From: Nolan, Chris <Chris.Nolan@lancashire.gov.uk>
Sent: 26 January 2018 12:56
To: Stephen Kilmartin; planning
Cc: LHS Customer Service
Subject: D3.2018.0008 - 30 Peel Park Avenue and land to the rear Clitheroe

Planning Application No: 3/2018/0008

Proposal: Demolition of existing dwelling and erection of 34 bungalows for the over 55s with associated access, parking, landscaping and open space.

Location: 30 Peel Park Avenue and land to the rear Clitheroe BB7 1ET

PROPOSED HIGHWAY
ACCESS LAYOUT

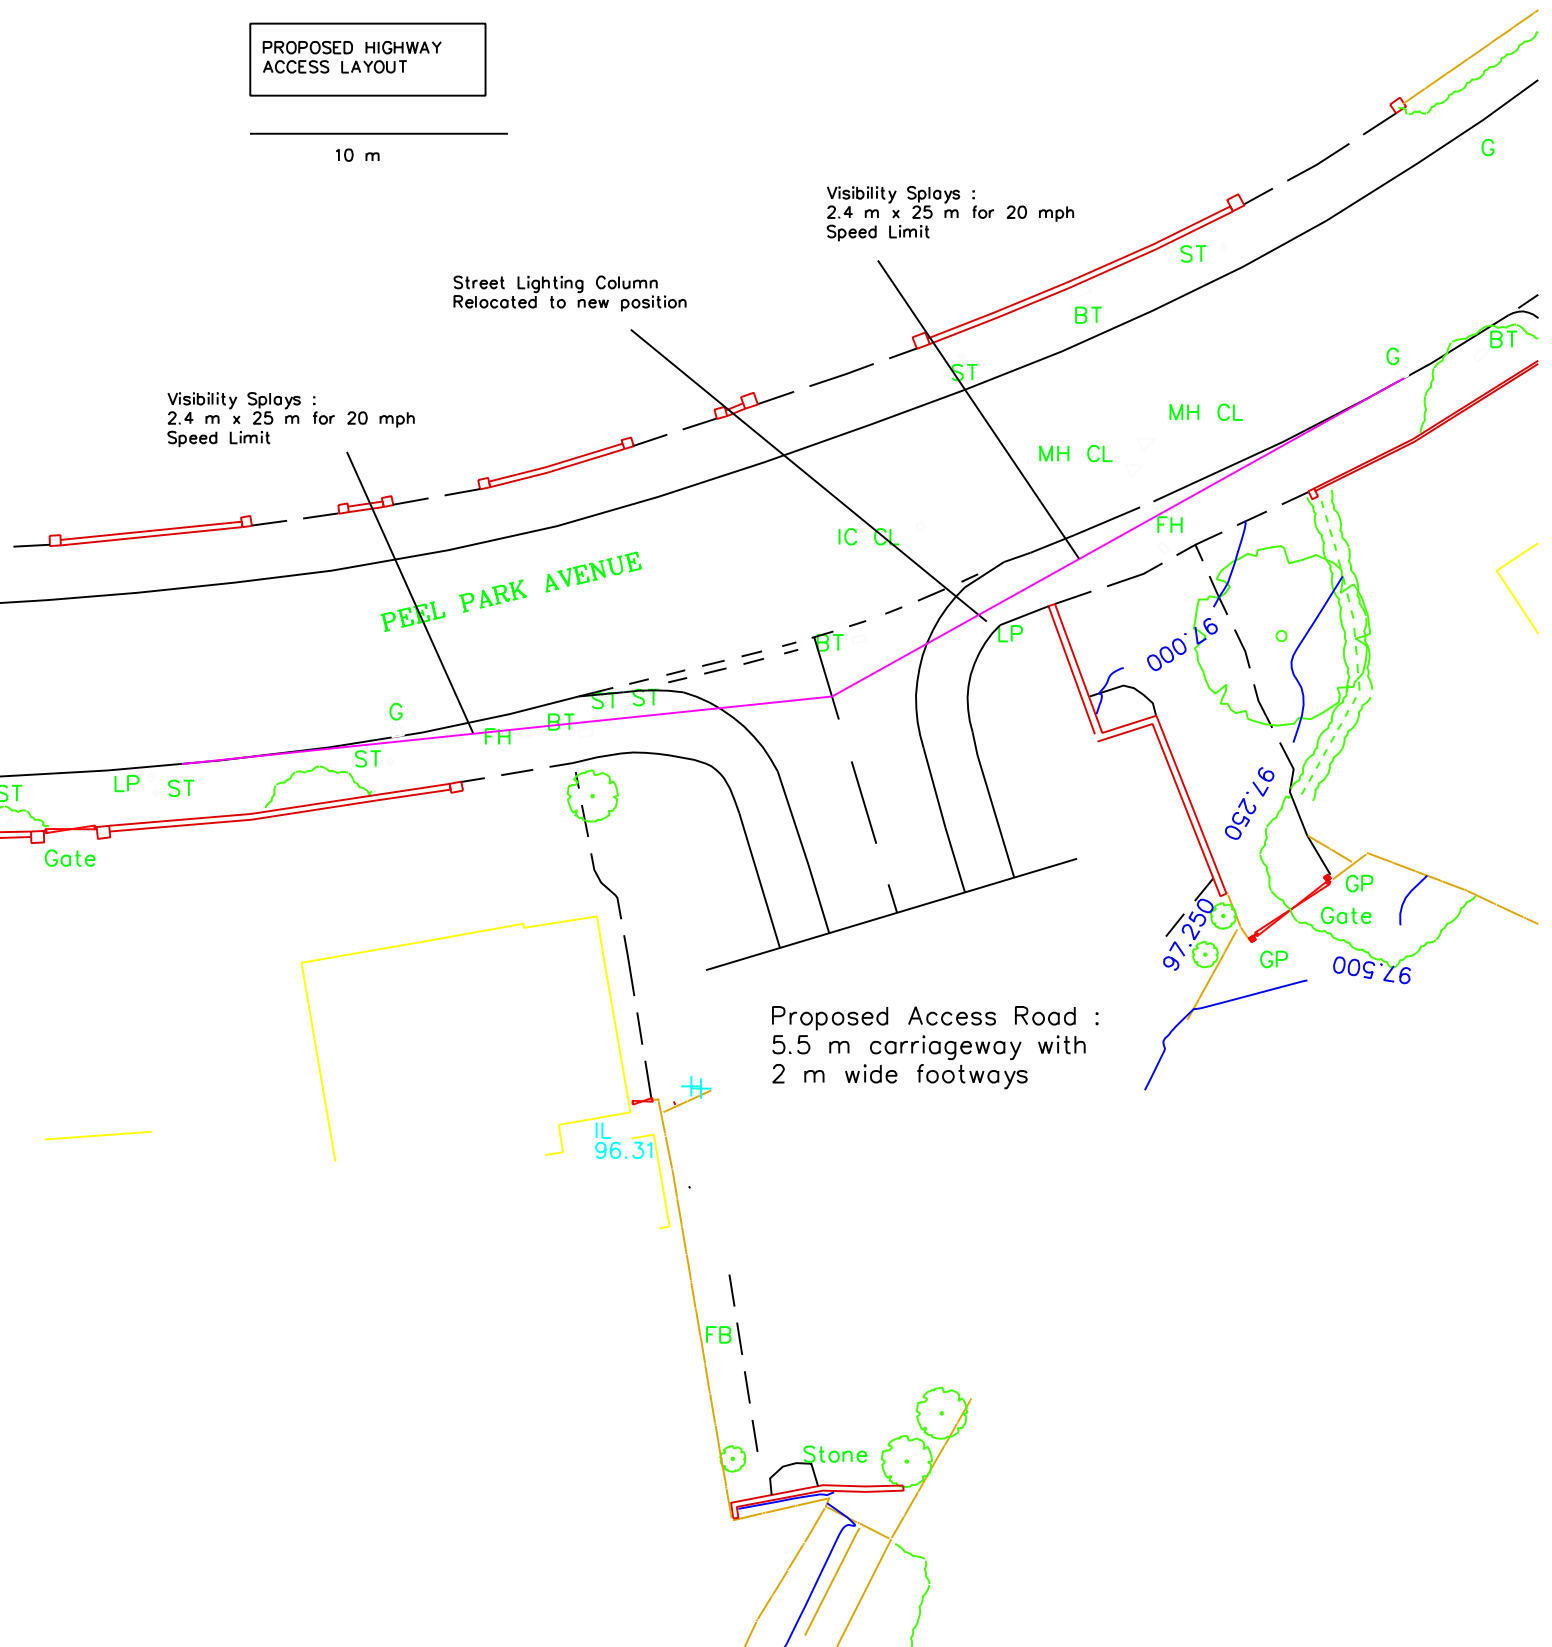
With regard to the above planning application for 34 bungalows. In principal I would not have objections to the application but I have concerns with regard to the layout of the site I would like some more detail with regard tertiary roads on the site.

I would be looking for roads serving three or more houses to be designed and built to adoptable standards. This is a Policy of the county council. I appreciate that the entrance road is indicated a road that will be built to this level but the roads serving the vast majority of the properties would not meet our requirements. I would be looking the adoptable roads to extend to at least between plots 11 & 27 for one length and to between 21 & 30 on the other length. This will allow for a turning head in front of these plots. The Design and Access Statement indicates that the use of the longer lengths of tertiary roads were used to encourage lower speeds and as much as this is appreciated I feel that it is more important to offer an adopted road and to use other measures to keep drivers speeds low such as raised junction tables.

I would be looking for the adoptable roads to have a minimum width of 5.5m and footways at both sides of a minimum width of 2m.
